From: Amanda Scholes on behalf of Planning.Responses
Sent: 27 April 2018 08:22
To: Planning Scanning; Karen Parsons
Subject: FW: 1 Seaton Road LU/33/18/HH

Subject: 1 Seaton Road LU/33/18/HH

ELEVATIONS AS PROPOSED

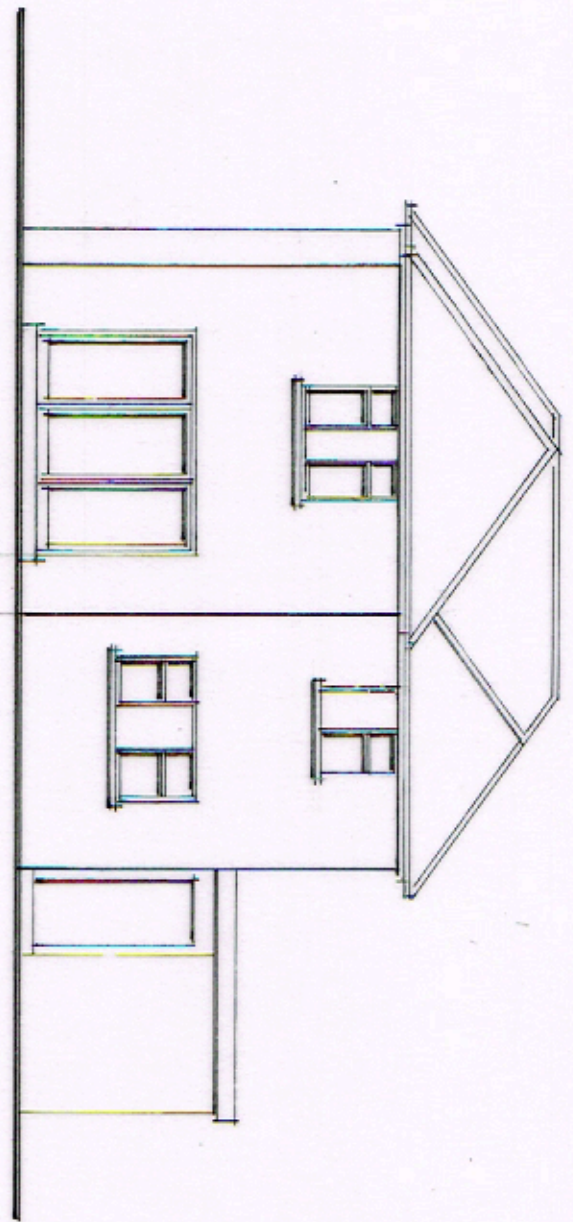
The neighbouring property No.3 has what appears to be a bedroom window in rear elevation set back behind the rear building line of No.1. My concern is the impact of the two storey extension on the this habitable room. To assess such matters the Council usually take a 45 degree line off the centre point of the nearest window. In this case this line is breached and I feel that the two storey extension will have an adverse impact upon this window and the amenity of the adjoining occupiers.
